Your ref: 3/2013/0137
Our ref: DC/13/797
Date: 09-MAY-13

Location: Land to the East of Clitheroe Road, Whalley
Proposal: A residential Mixed development comprising up to 260 dwelling, primary school and associated works

Client: Commercial Estates Group			
Project: Whalley			
Title: Parameter Plan			
Status:			
Designed:	Drawn: HE	Checked: AR	
Scale: 1:1000@A1	Date: 1/02/13	Approved: AR	
Drawing No: PL1158.3.M.101			Revision: A

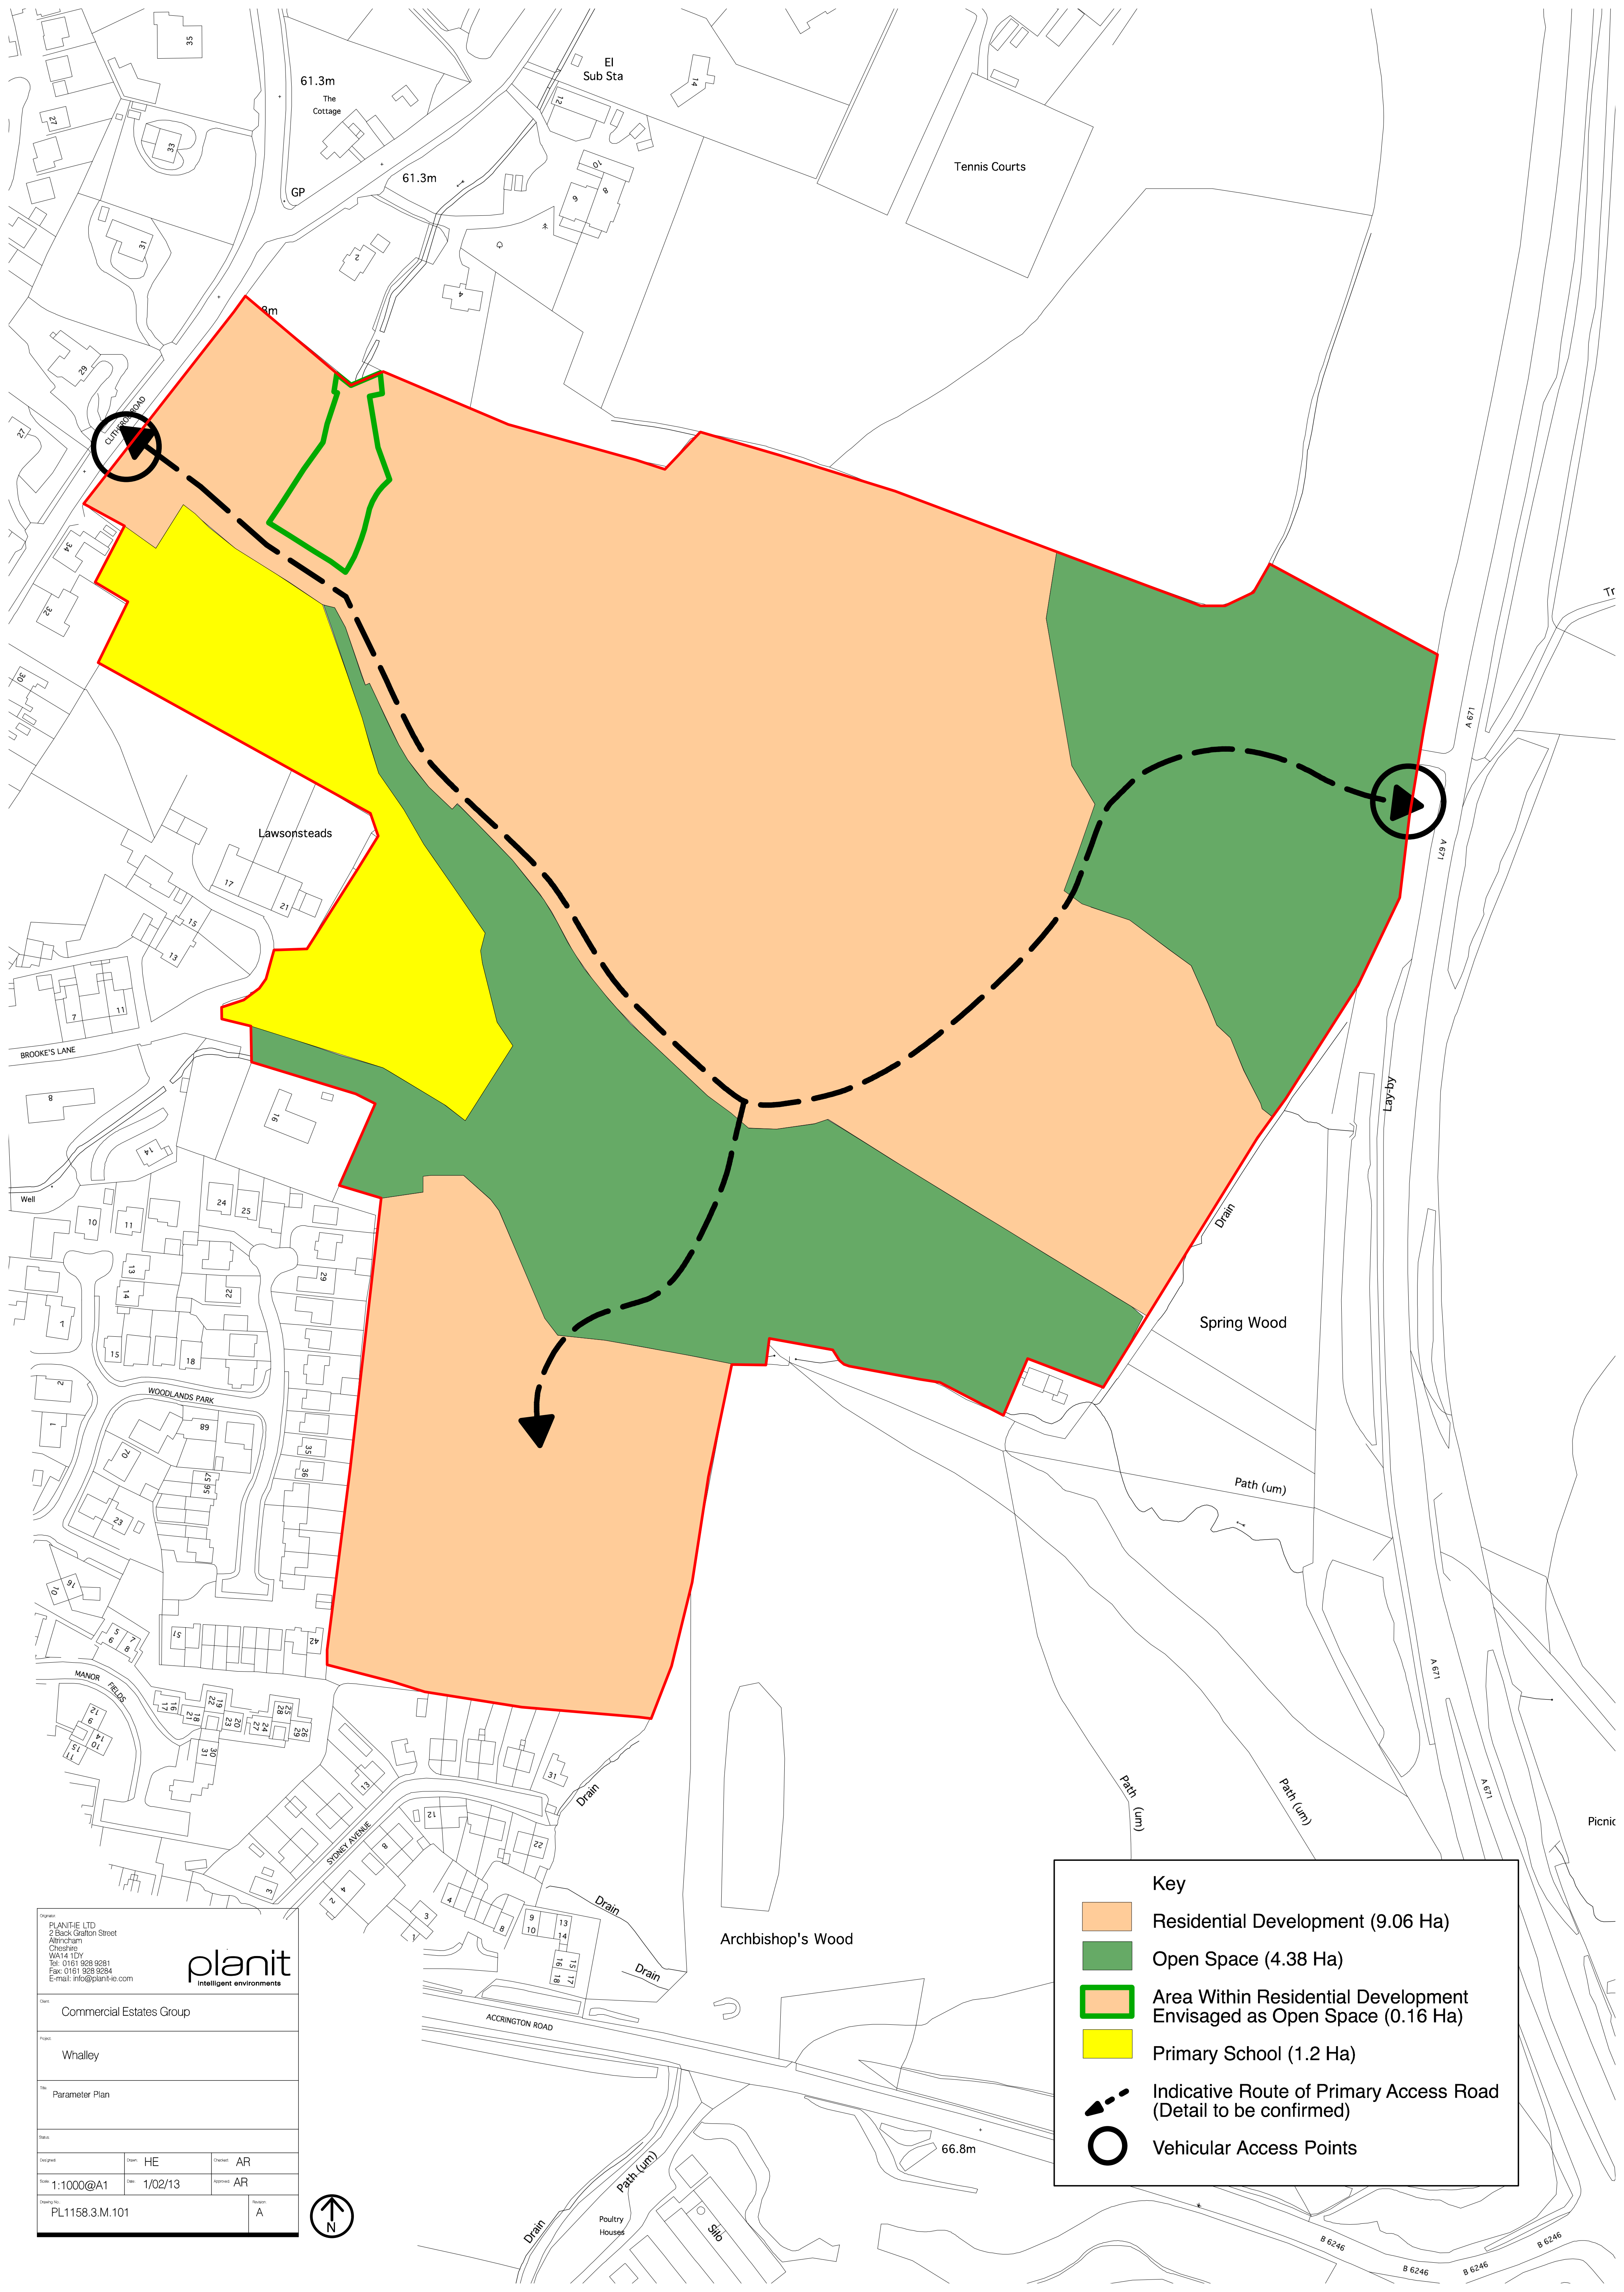
- An aqueduct and water distribution mains cross the site. As we need access for operating and maintaining them, we will not permit development in close proximity to these pipes. Therefore a modification of the site layout would be necessary. Although the aqueduct cannot be diverted, any diversion of the distribution mains would be carried out at the applicant's expense.
